From: Anita Gardner
Sent: 13 February 2018 08:42
To: Karen Parsons
Subject: FW: Proposed KFC at Fontwell - LPA ref WA/88/17

Anita Gardner | Principal Planner, Directorate of Place, Arun District Council | Location: First Floor, Arun Civic Centre, Maltravers Road, Littlehampton, BN17 5LF

1. The application letter states "there are no proposed works to the attached Burger King unit" but the plans show a 48 sq m triangular extension. Which is correct? Is Burger King being extended or not?

PROPOSED GENERAL
ARRANGEMENT PLAN

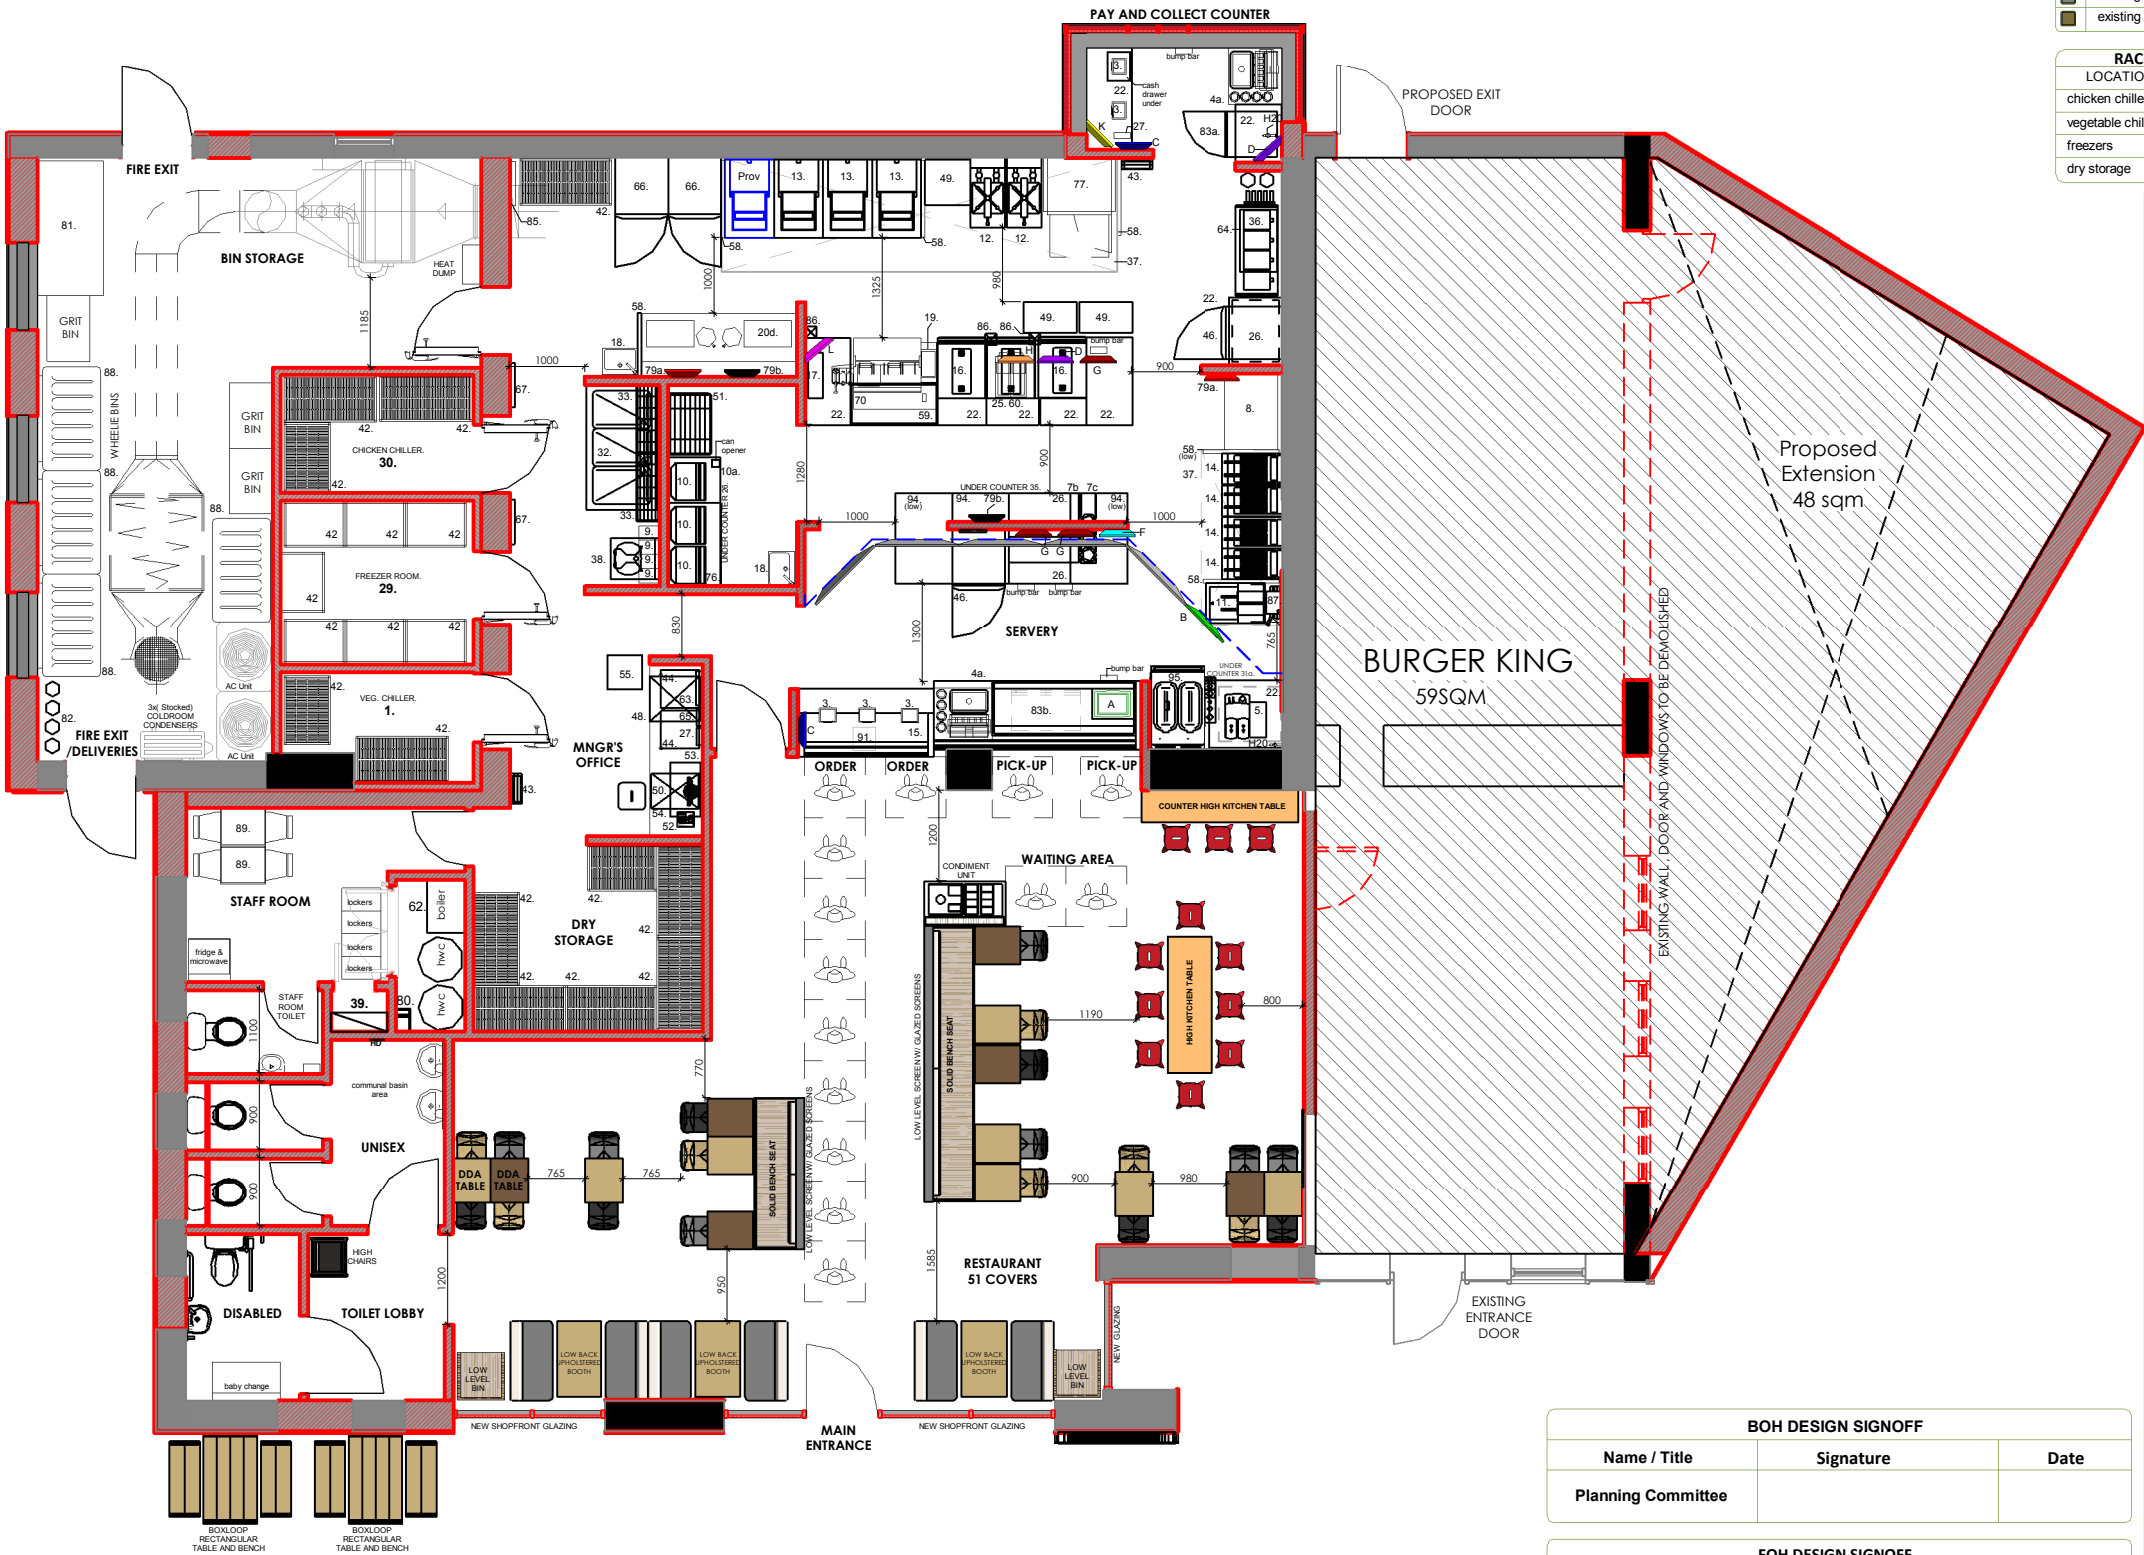
This should be clarified

4. Can the applicant confirm whether they consider the number of wash-hand-basins in the KFC kitchen to be sufficient (2 no.).

5. Please could the applicant confirm the number of covers for this premises, so that Environmental Health can assess whether the sanitary provision is sufficient.

1. There are no external alterations or extensions proposed to Burger King. There may be an internal refit but no external changes are proposed
2. We would be happy to accept a condition restricting the hours of operation of the KFC and drive thru to 0700-2300. Would that be acceptable - my thoughts are that this would address EHO concerns on movements / noise and also comments raised by residents.
3. With regards the boundary with Travel Lodge - could boundary details / landscaping be conditioned?
